Application number: 2024/91127	
What is the application for?:	Conversion of garage to living space, erection of detached double garage and off
Address of the site or building:	37, Oaklands Crescent, Birchencliffe, Huddersfield, HD2 2FX
Postcode:	HD2 2FX

Project: PROPOSED GARAGE PLANS

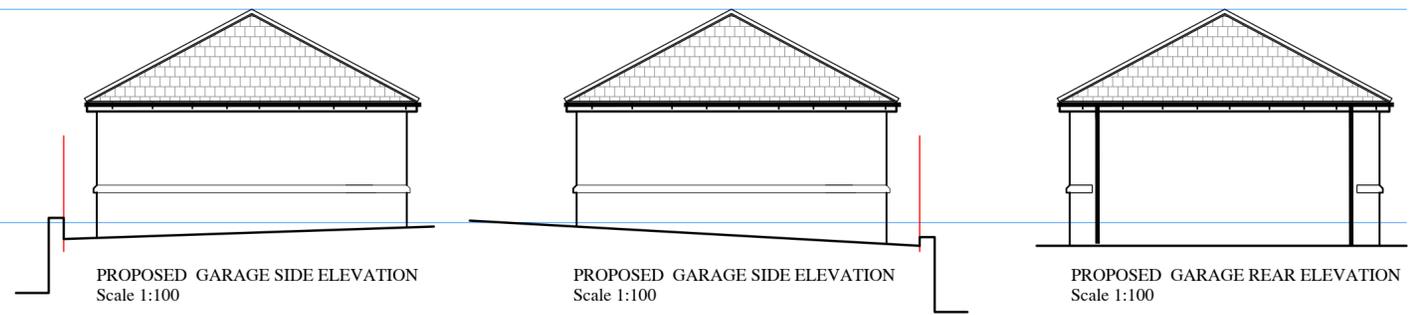
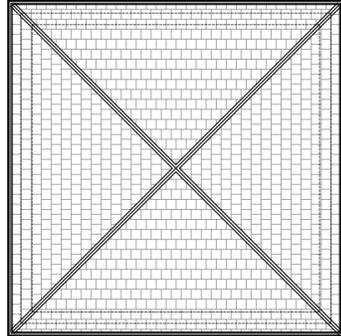
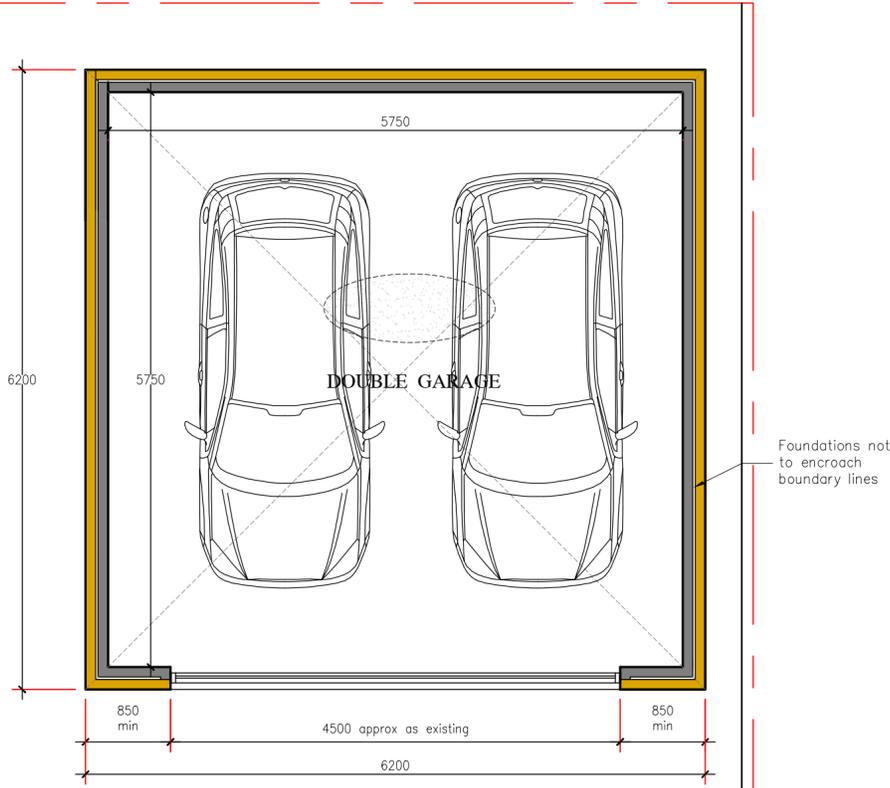
Type of comment: An objection	
Do you wish your comments to be published on the website anonymously?	No
<p>The erection of the new proposed garage could further compromise the boundary wall and footings. We are next to, and lower by 2 meters to be exact than the property having the building work done and already get an excessive amount of water coming through the boundary wall in several places. (I can provide photos if necessary) The grass in our garden will not grow with lots of dead patches and moss creeping across the garden due to flooding.</p> <p>I am worried that building work would further damage the boundary wall and the footings causing a more catastrophic effect on flooding (excessive water) into my garden and property 149 with nowhere for this water to go as there is no drainage to take the water away.</p> <p>I am not against the building work of the garage or cinema room, I am more concerned about the ground being disturbed as it is already settled over 4 years and disturbing it will cause more flooding and damage to the boundary wall footings.</p> <p>I think a more excessive plan and outline on what drainage system is going to be put in need to be addressed to not make the matters worse. If it is made worse over the erection of the garage and cinema room, further legal action will be taken and possibly compensation.</p>
